From

Lr.No. 42/11597/90

Sub: MMDA - Planning permission - Construc-
tion of Residential building in S.No.
327/10 of Minjur village - Approval of r
Regarding.

PLAN SECTION ON XX
 DETAILS OF BATH & LAVATORY
 SCALE 1" = 8'-0" (1:100)

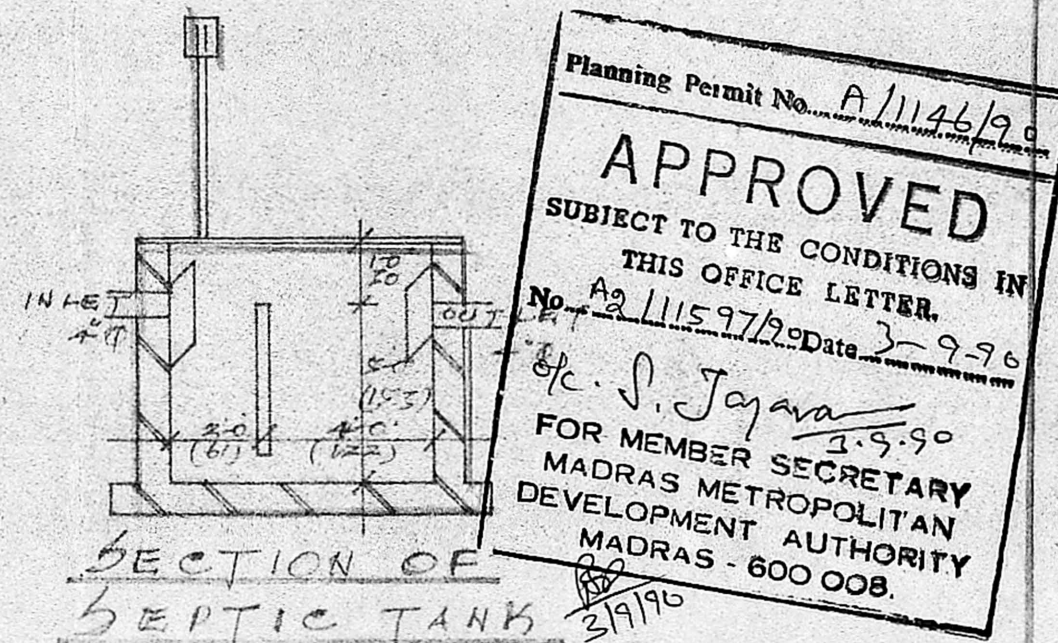
towards Regularisation charge by two separate Demand drafts
of a Nationalised Bank in Madras city drawn in favour of the
Member-Secretary, MMDA, Madras-8 or in-cash/and pay at MMDA
office cash counter between 10.00AM and 4.00PM within 10 days
and after remit the said amount, you are requested to remit
the duplicate receipt to Area Plans Unit. You are also request-
ed to submit the Affidavit for ULC in Rs.5/-stamp paper duly
attested by Notary public. Planning permission application will
be returned unapproved if the amount are not paid within the
stipulated time. You are also requested to furnish revised plans
deleting bath and water clearance in side set back.
